Project No. 21101

**Re: PA22-024- Marysville 44th PRD – Technical Review 3  
7315 / 7417 44th St NE – APN(s) 30053500303700 / 30053500303600**

This letter is provided as response to comments dated May 16, 2023. Each item has been carefully reviewed and considered and the following is a summary of how each item was addressed.

DRAWING: **C3**
 SHEET: **3** OF **9**

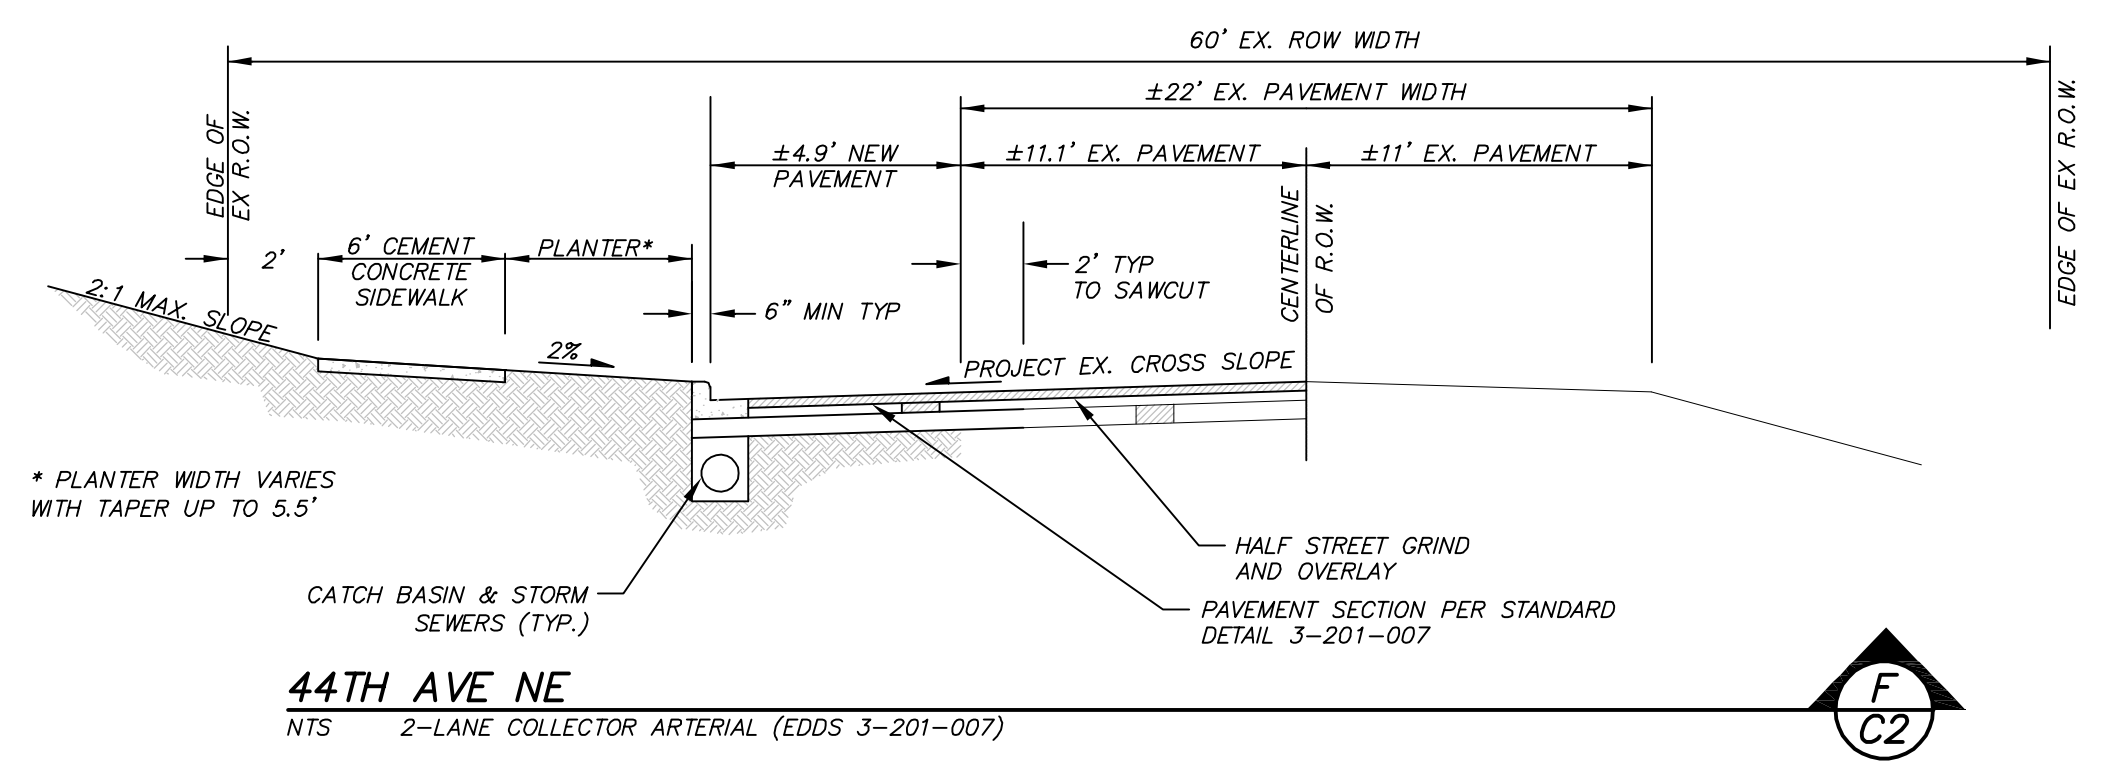
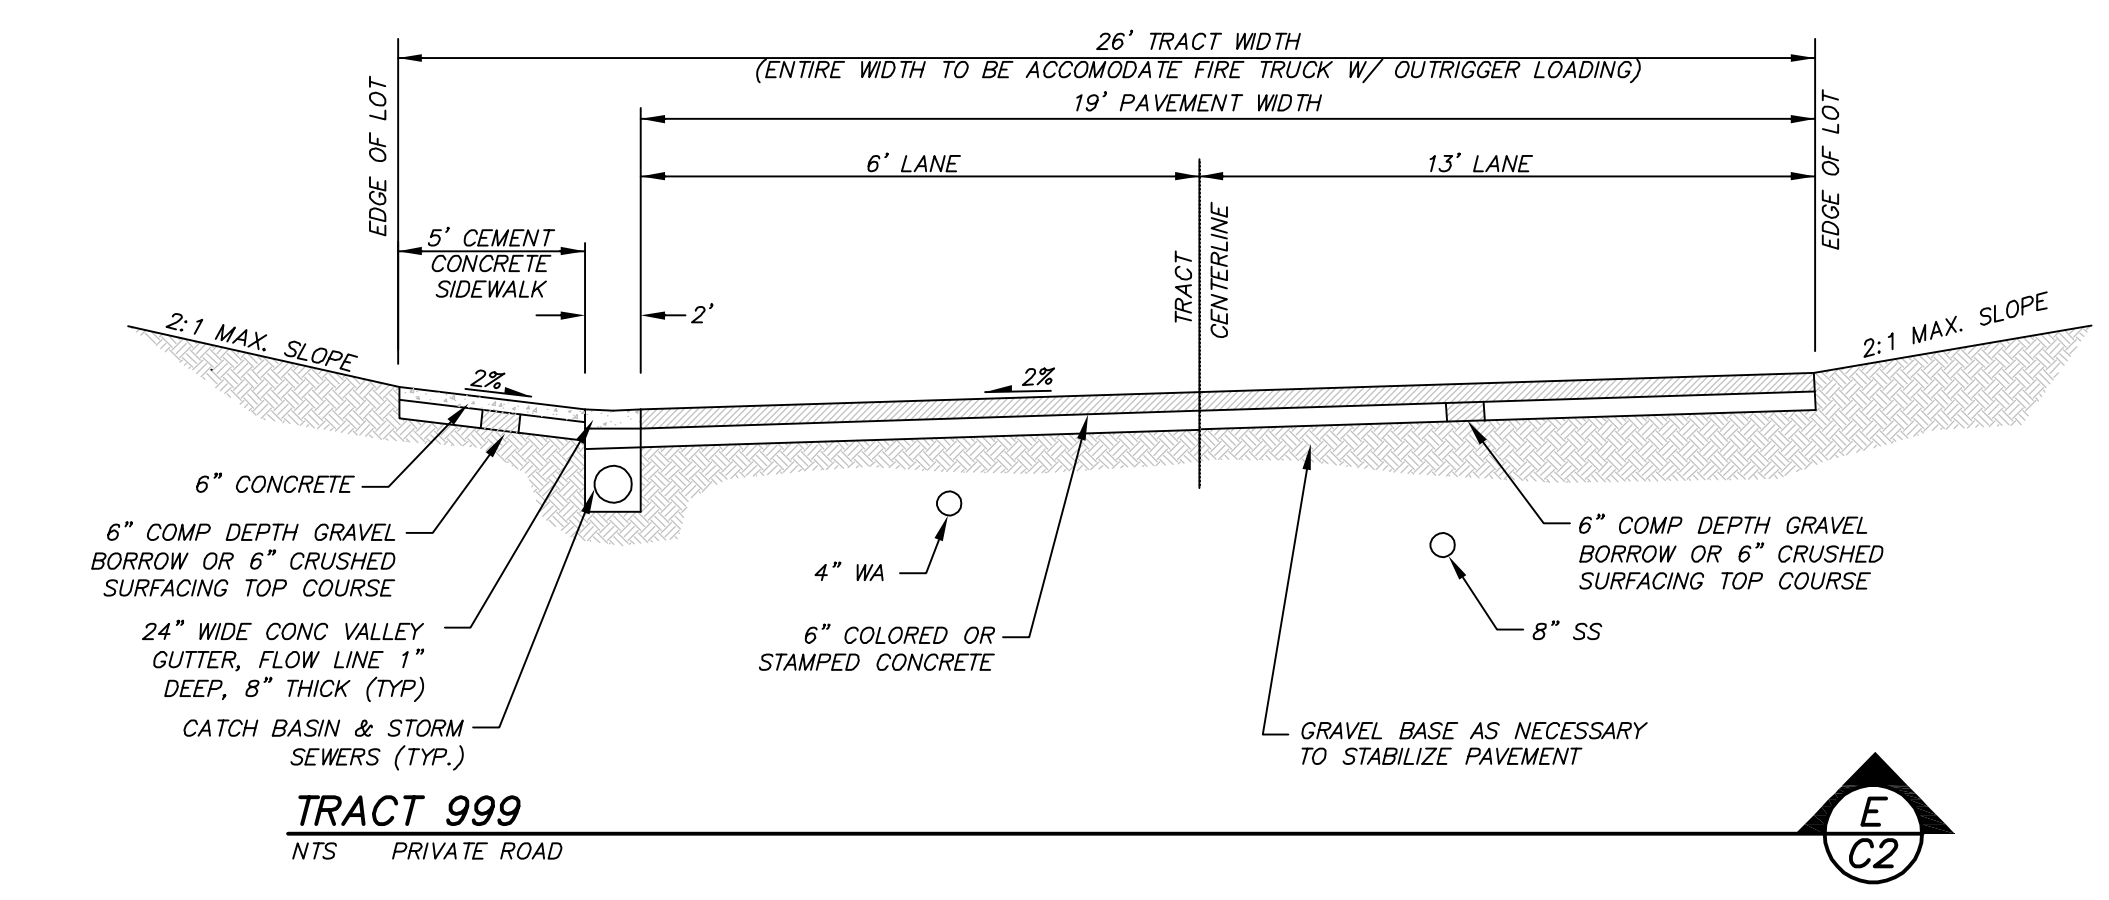
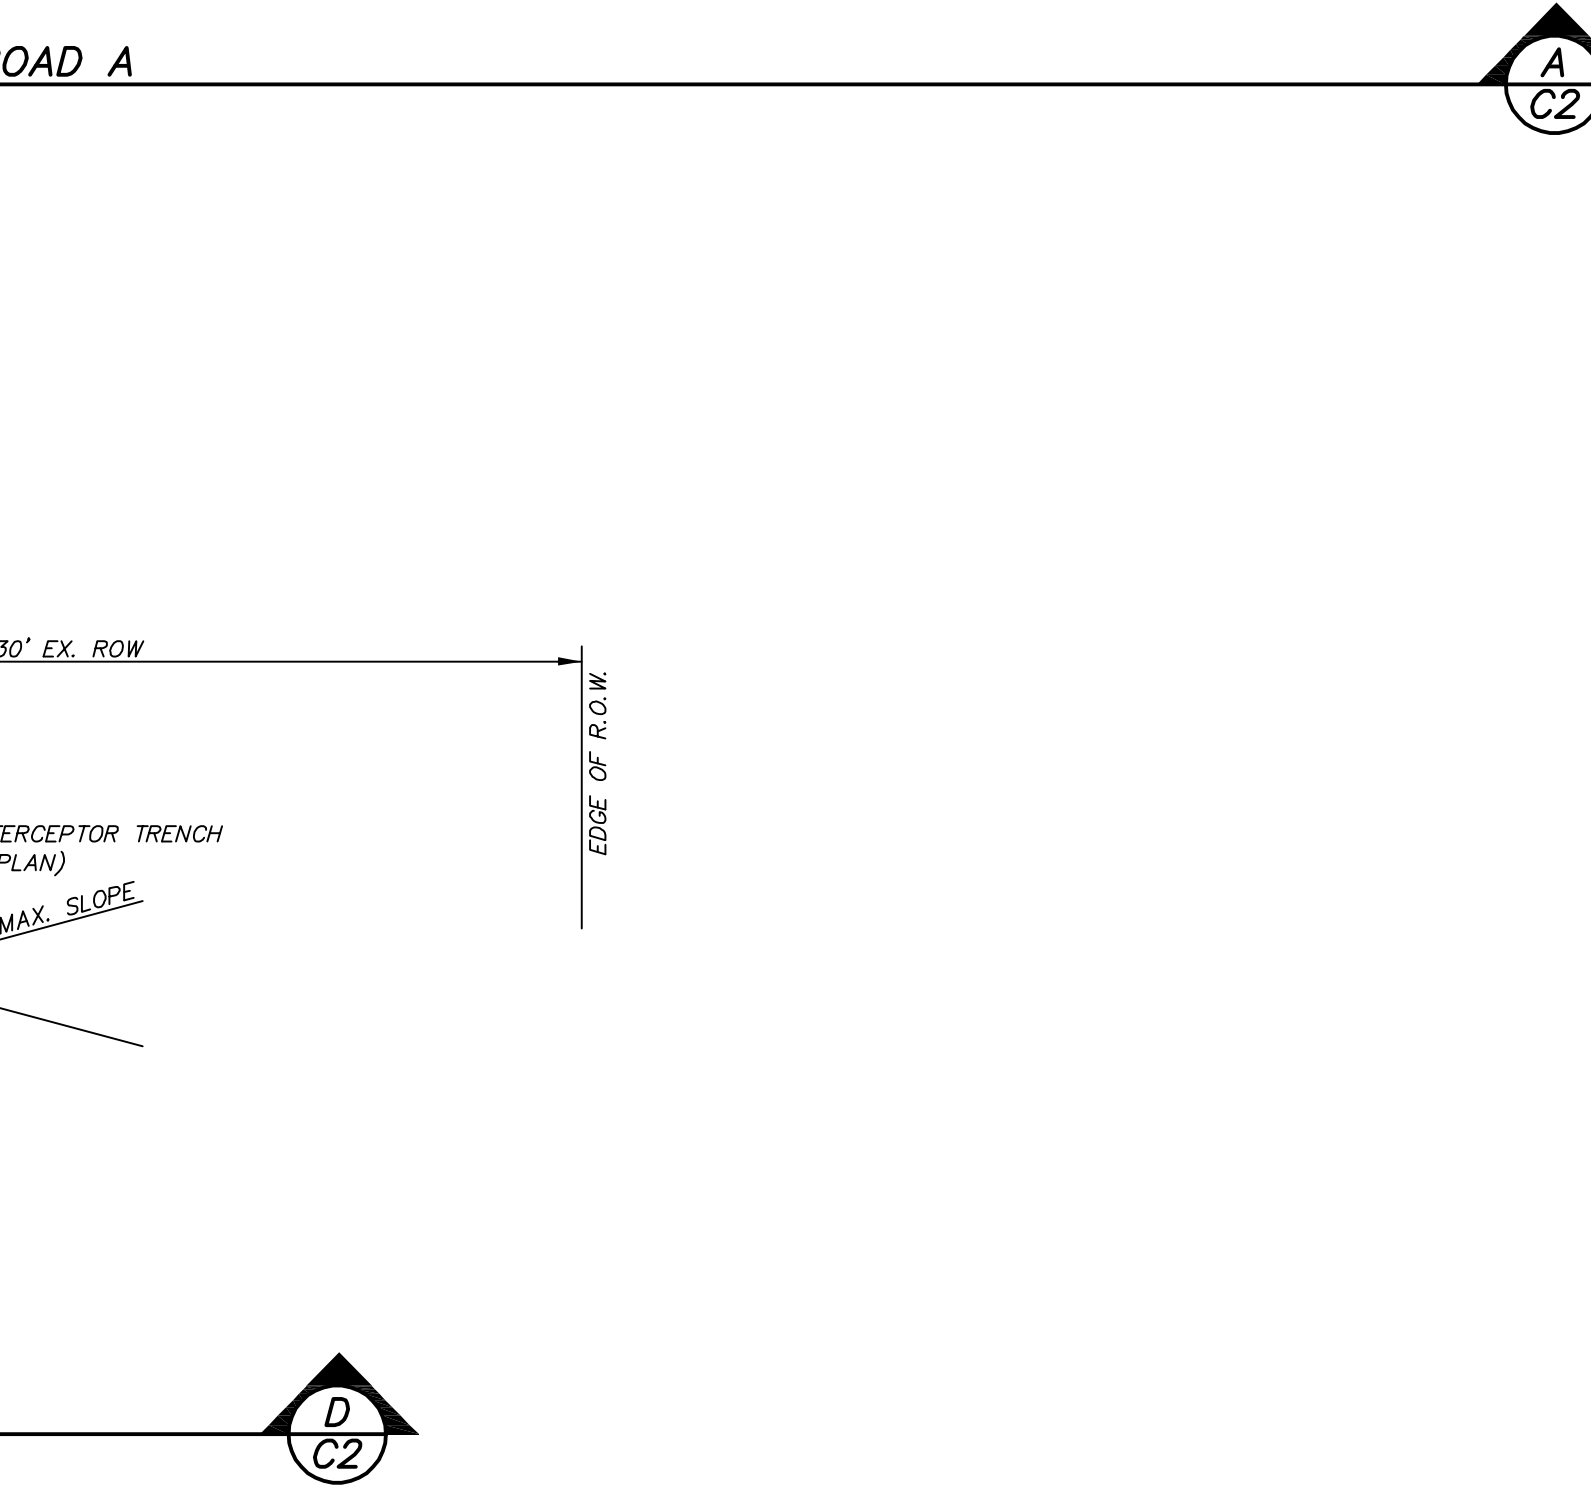
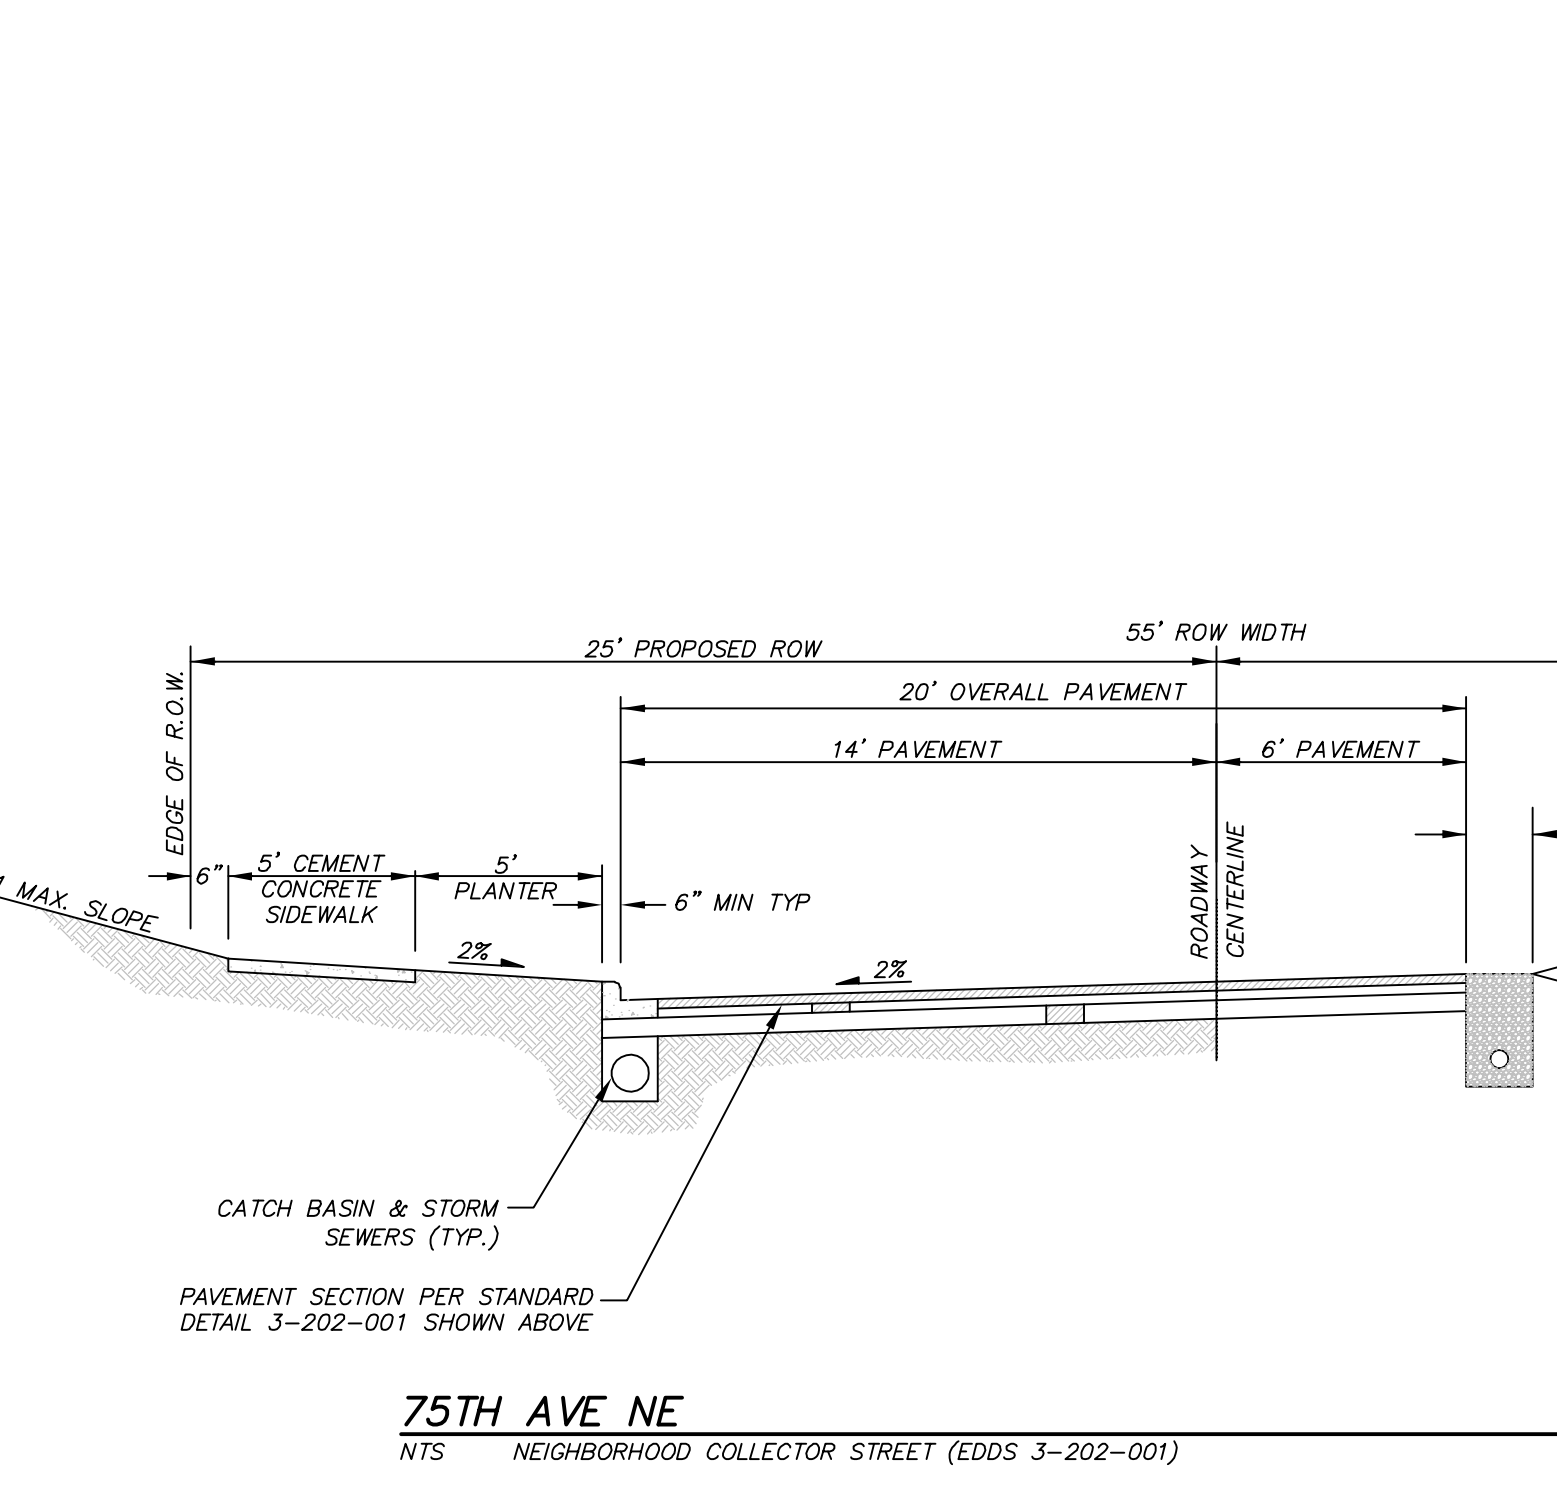
1. The auto court portion is 26 foot wide, but the sidewalk will be constructed level with pavement to allow for a wider section in case of obstruction by illegally parked cars.

***The auto court design and typical section has been revised to construct the sidewalk level with the pavement to provide a 26' wide driving surface.***
